City of Portland, Maine - Building or Use Permit Application
 389 Congress Street, 04101 Tel: (207) 874-8703, Fax: (207) 874-8716

Permit No: 05-1508	Issue Date:	CBL: 063 G007001
------------------------------	--------------------	----------------------------

Location of Construction: 187 VAUGHAN ST	Owner Name: Joe Tacka	Owner Address: 89 Deering Street	Phone:
Business Name:	Contractor Name: Scott Forbes	Contractor Address: 188 Capisic Street Portland	Phone 2077723380
Lessee/Buyer's Name	Phone:	Permit Type: Alterations - Duplex	Zone:

Past Use: 2 Unit residential	Proposed Use: 2 unit residential/ interior renovations/ build deck	Permit Fee: \$111.00	Cost of Work: \$10,000.00	CEO District: 2
Proposed Project Description: interior renovations/ build deck		FIRE DEPT: <input type="checkbox"/> Approved <input type="checkbox"/> Denied	INSPECTION: Use Group: Type	
		Signature:	Signature:	
PEDESTRIAN ACTIVITIES DISTRICT (P.A.D.)				
Action: <input type="checkbox"/> Approved <input type="checkbox"/> Approved w/Condition <input type="checkbox"/> Denied				
Signature:		Date:

RAILING DETAIL ELEVATION
N.T.S.

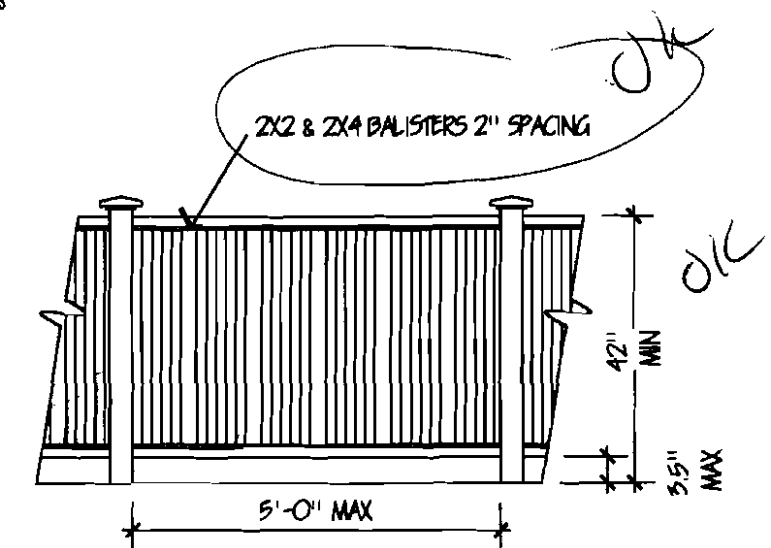
* Given the significance of the property, HP staff strongly recommends that the railing system not be constructed in pressure-treated lumber as proposed. Railing should be painted--not stained or left untreated.

3RD FLOOR CONSTRUCTION
PLAN

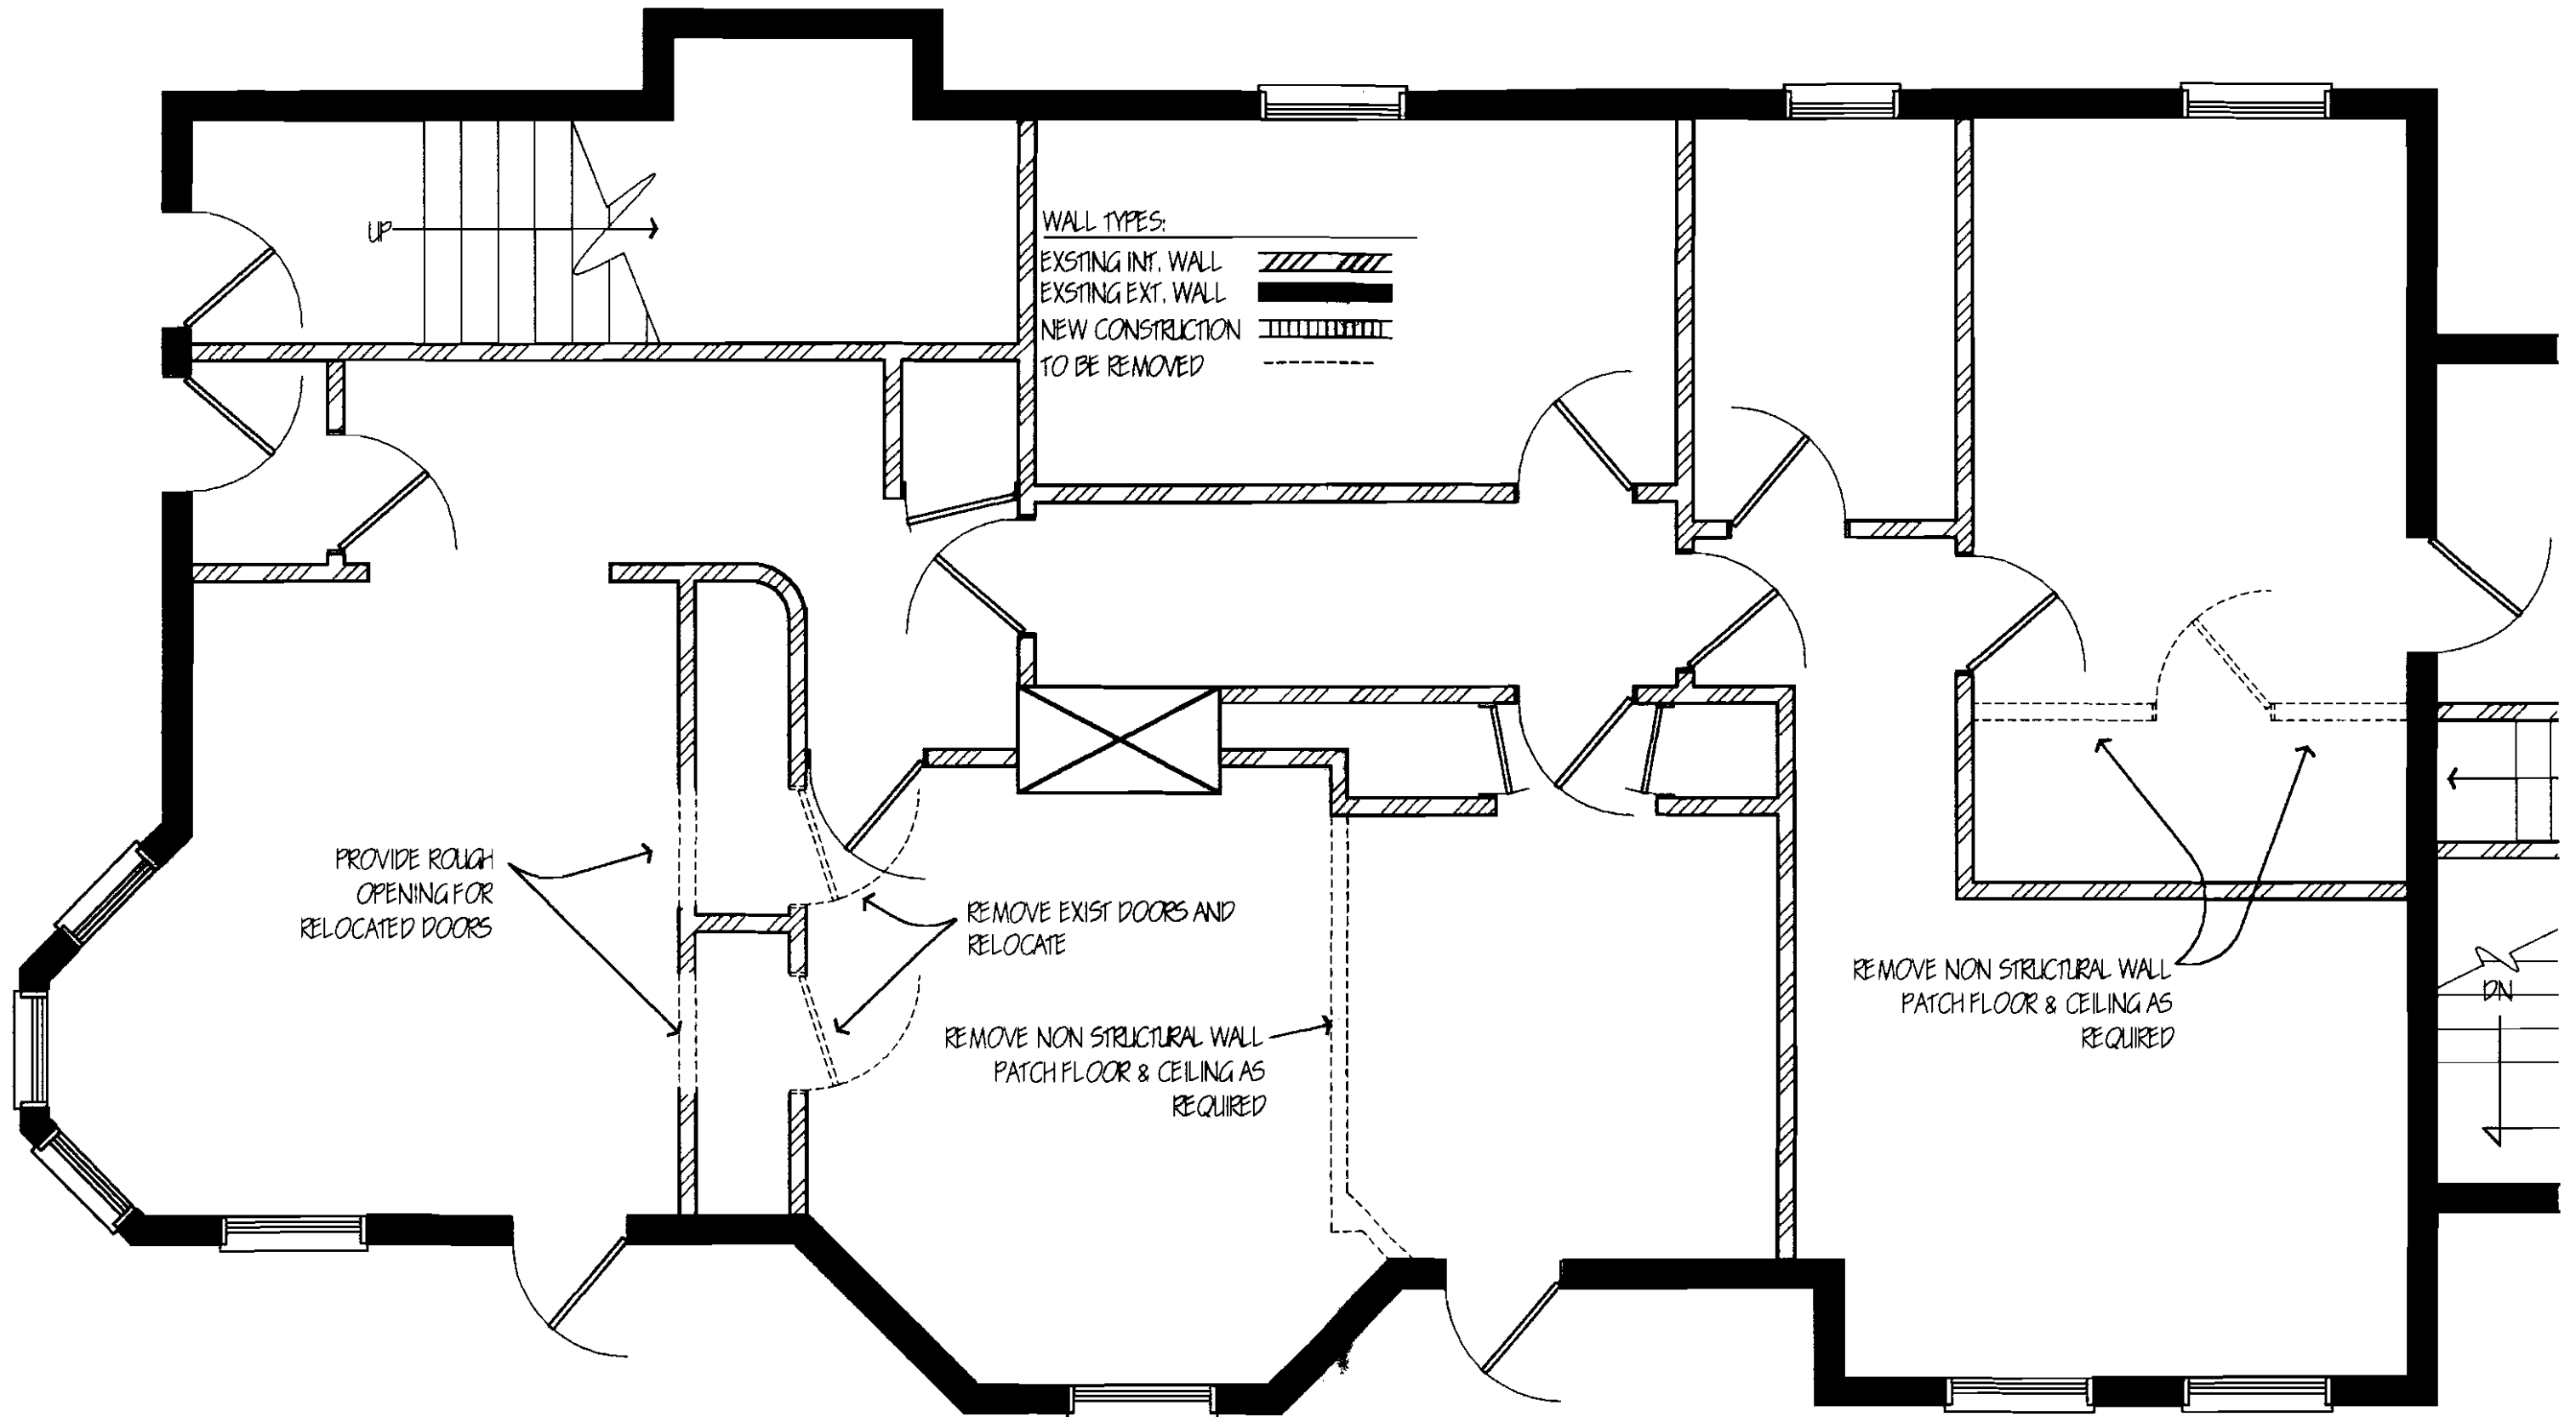
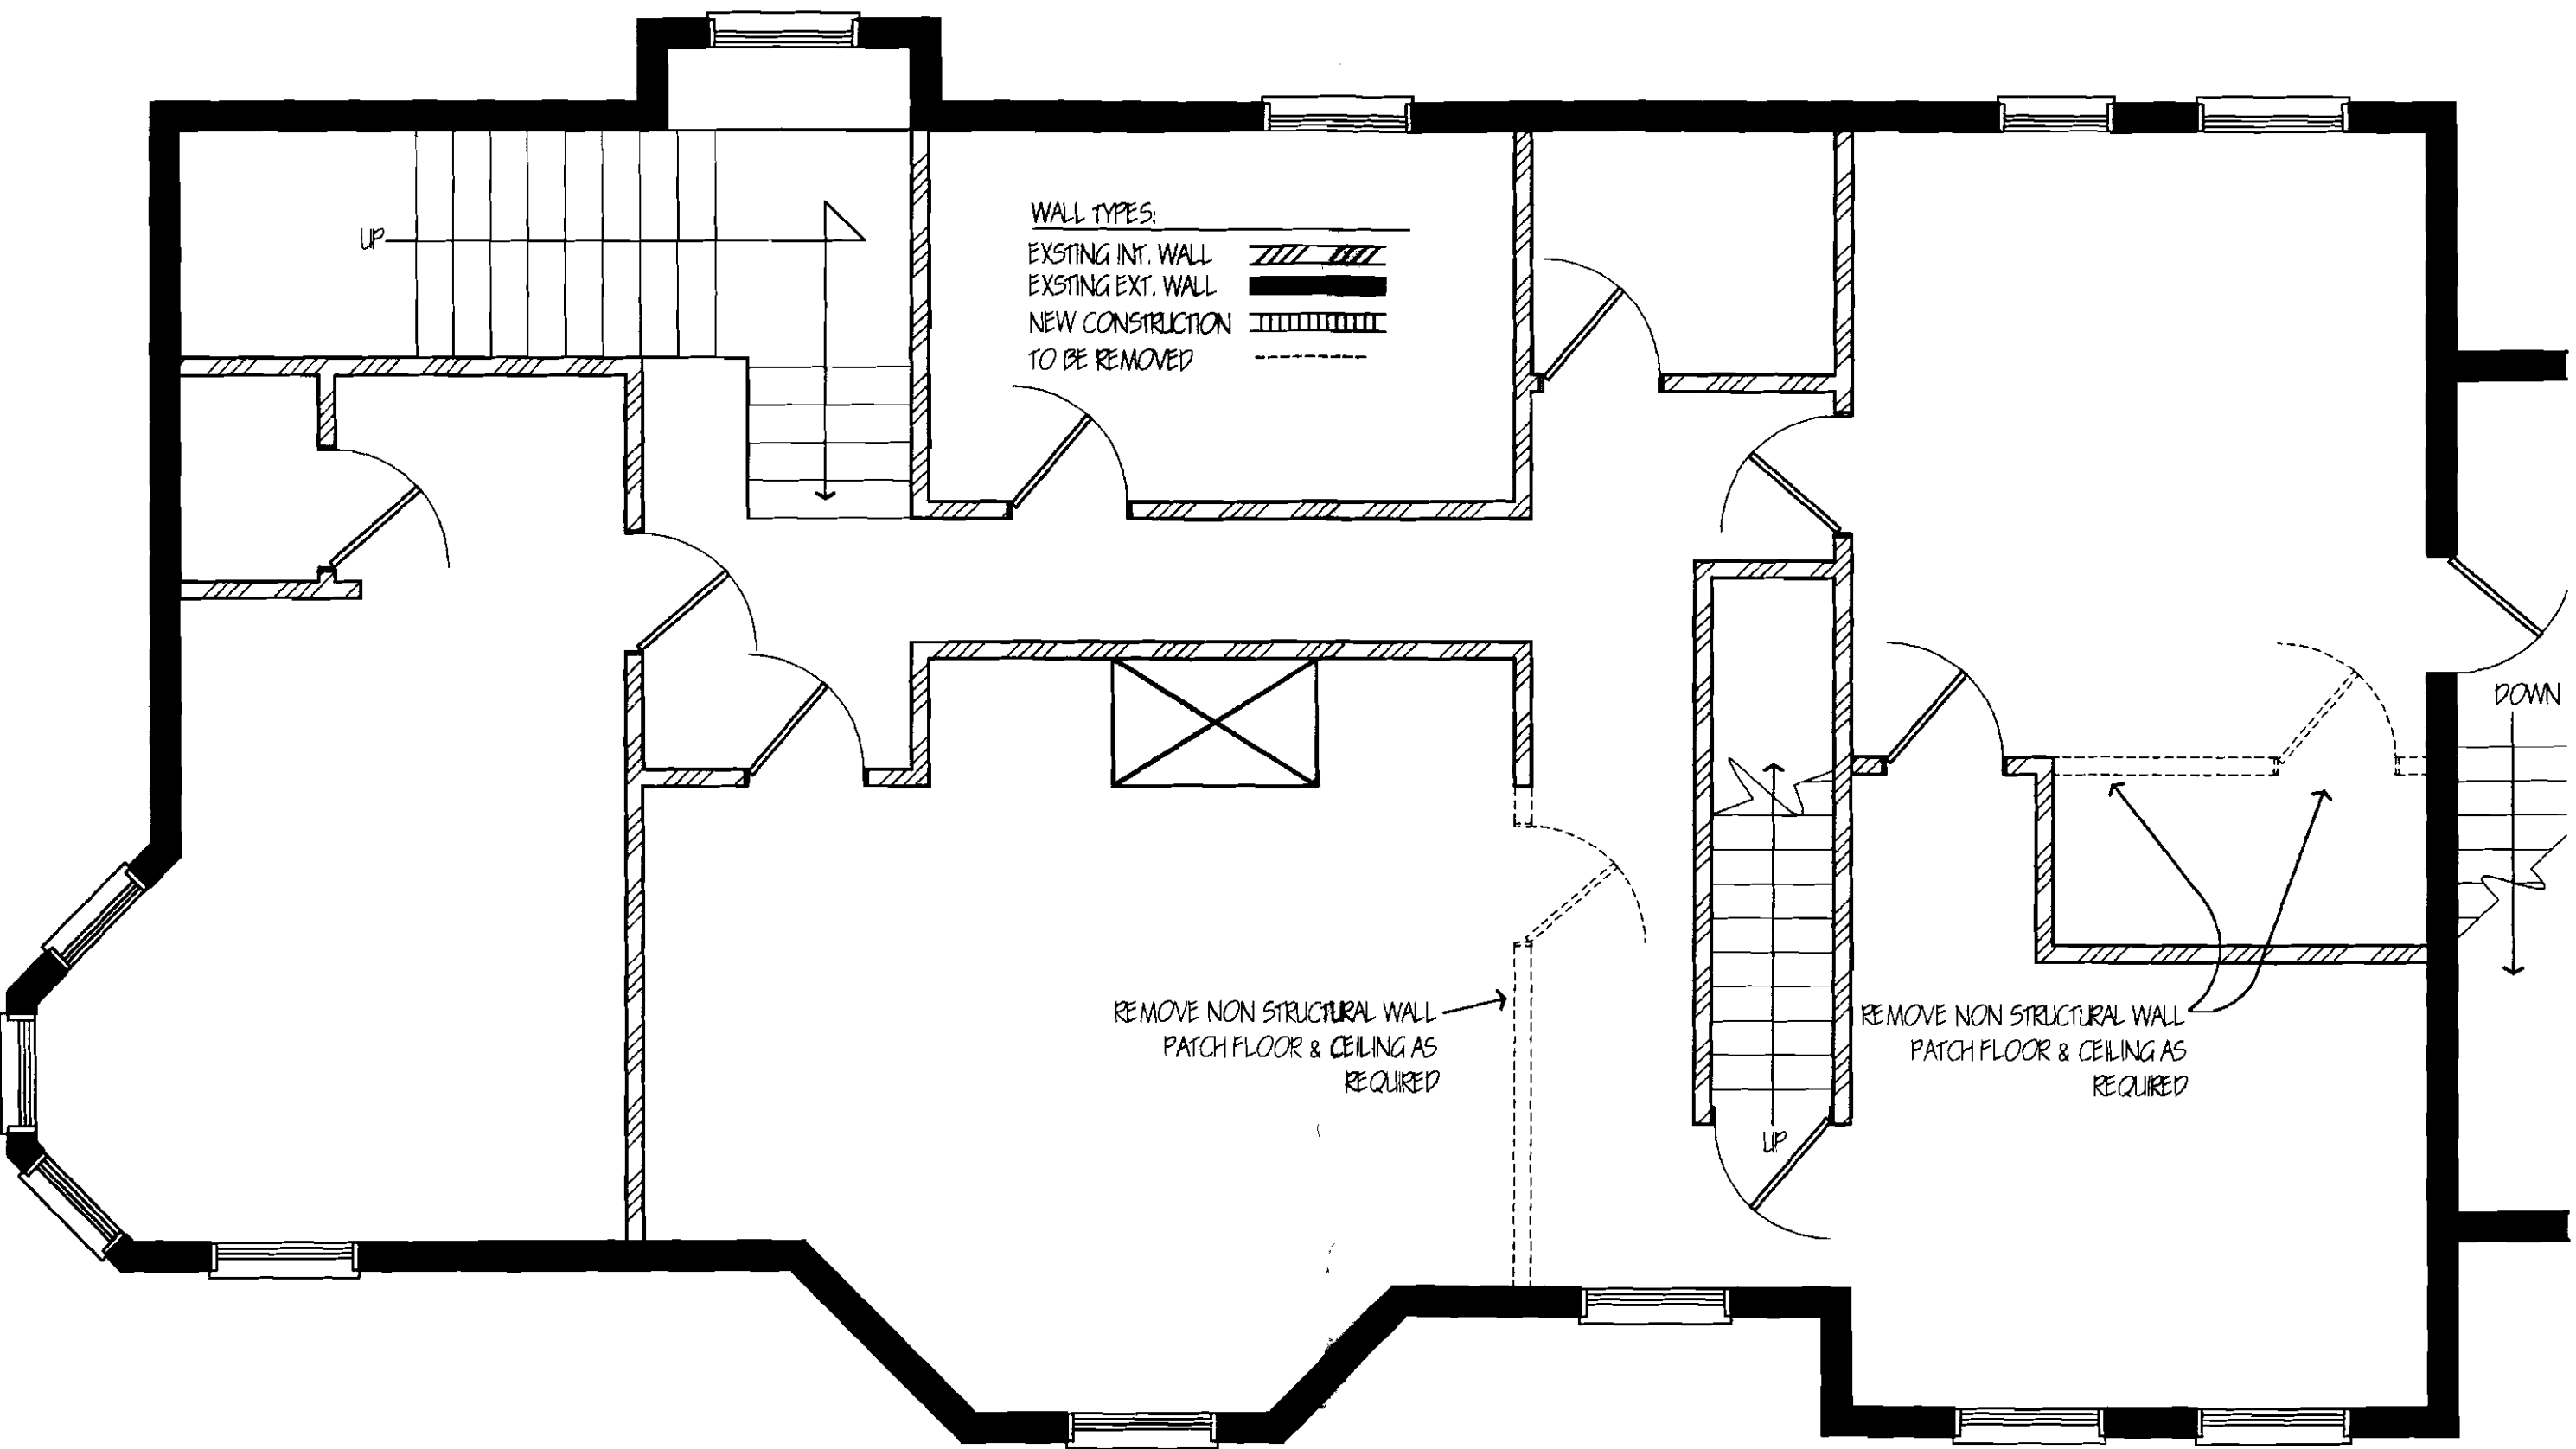
11/3/05-tm: spoke to Scott Forbes and told him we needed a plot plan and also a detailed drawing of what the 3rd story deck is sitting on for bearing points.

11/9/05-tm: received requested information from Joe Tacka
